Rezoning Transportation Analysis
Petition Number: Insert Zoning Petition #2020-182
General Location Identifier: Tax ID 08019306

Date	Description
01-21-21	First Review (WB)
03-25-22	Second Review (WB)
04-28-21	Third Review (WB)

Transportation Summary

1 SITE PLAN

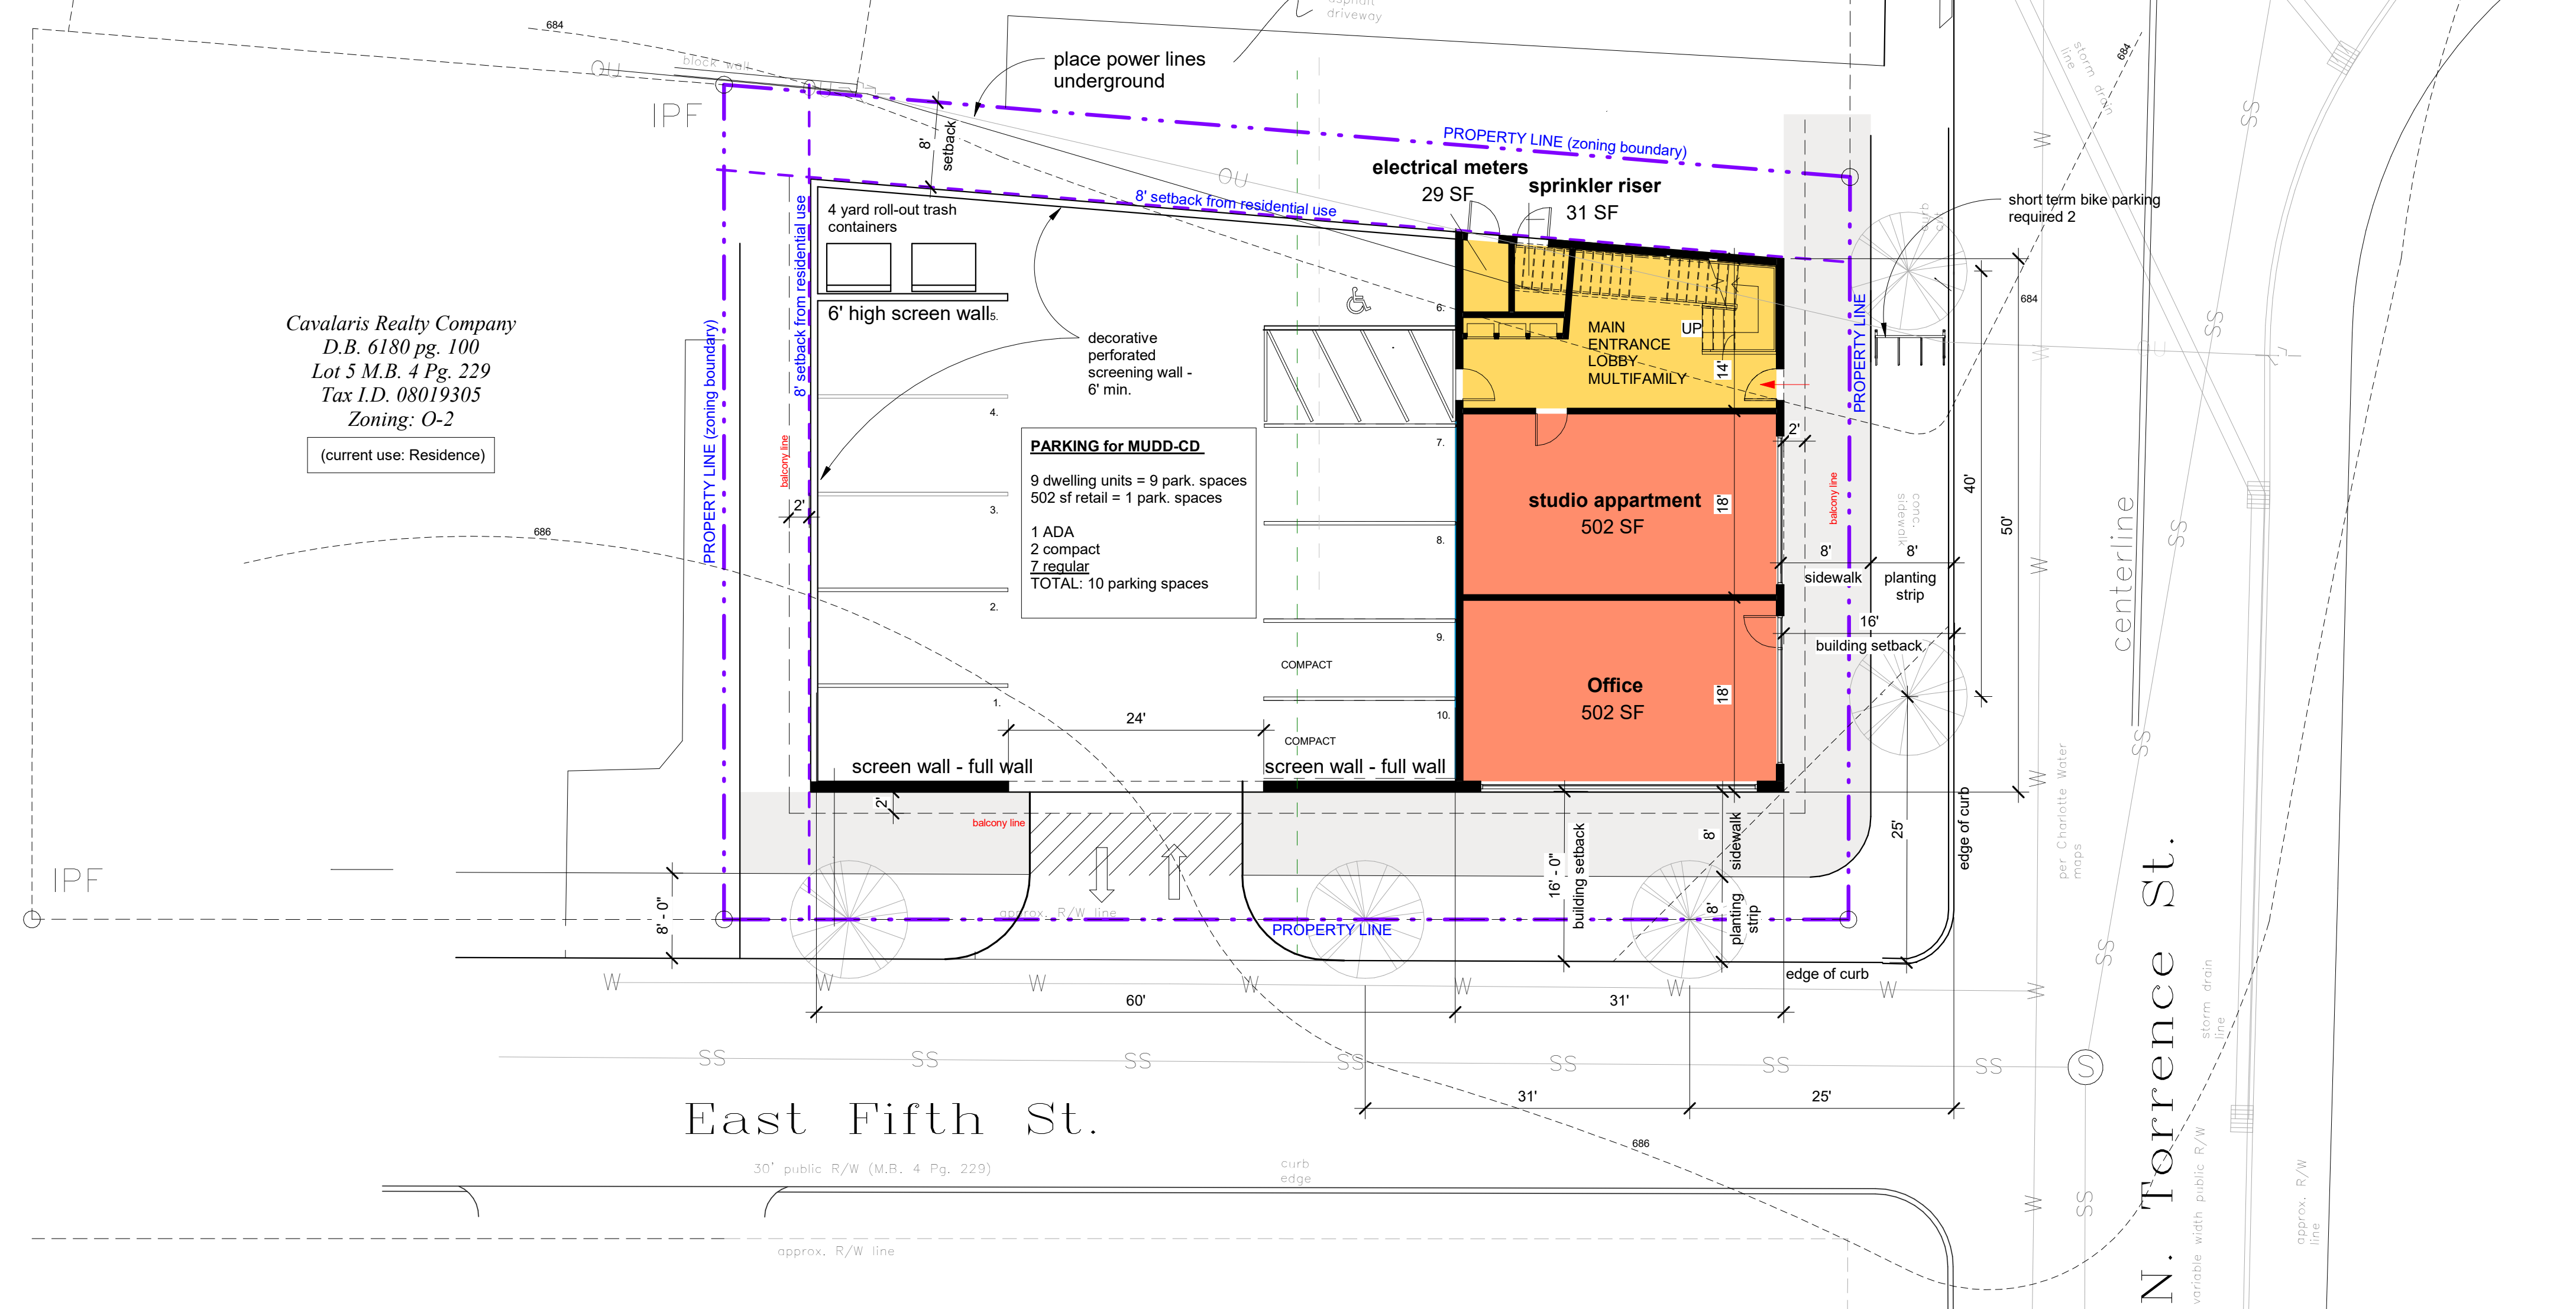
~~Label and dimension the curb and gutter from the centerline for each road on the site plan.~~

3. ~~Revise site plan and conditional note(s) to dedicate 25' right-of-way from the Torrance Street and Fifth Street centerlines per the Elizabeth Area plan. The site plan shall label and dimension the right-of-way from the road centerline.~~

4. ~~Revise site plan and conditional note(s) to commit to constructing an accessible ramp on the north quadrant of the intersection of 5th street and Torrance Street per ADA and PROWAG standards.~~

5. ~~Add a site plan note specifying dedication and fee simple conveyance of all rights-of-way to the City before the site's first building certificate of occupancy is issued. CDOT requests rights-of-way set at 2' behind back of sidewalk where feasible.~~

6. ~~Add a site plan note specifying that all transportation improvements will be approved and constructed before the site's first building certificate of occupancy is issued. The petitioner may phase transportation improvements if said improvements and phasing are explicitly described in site plan notes.~~
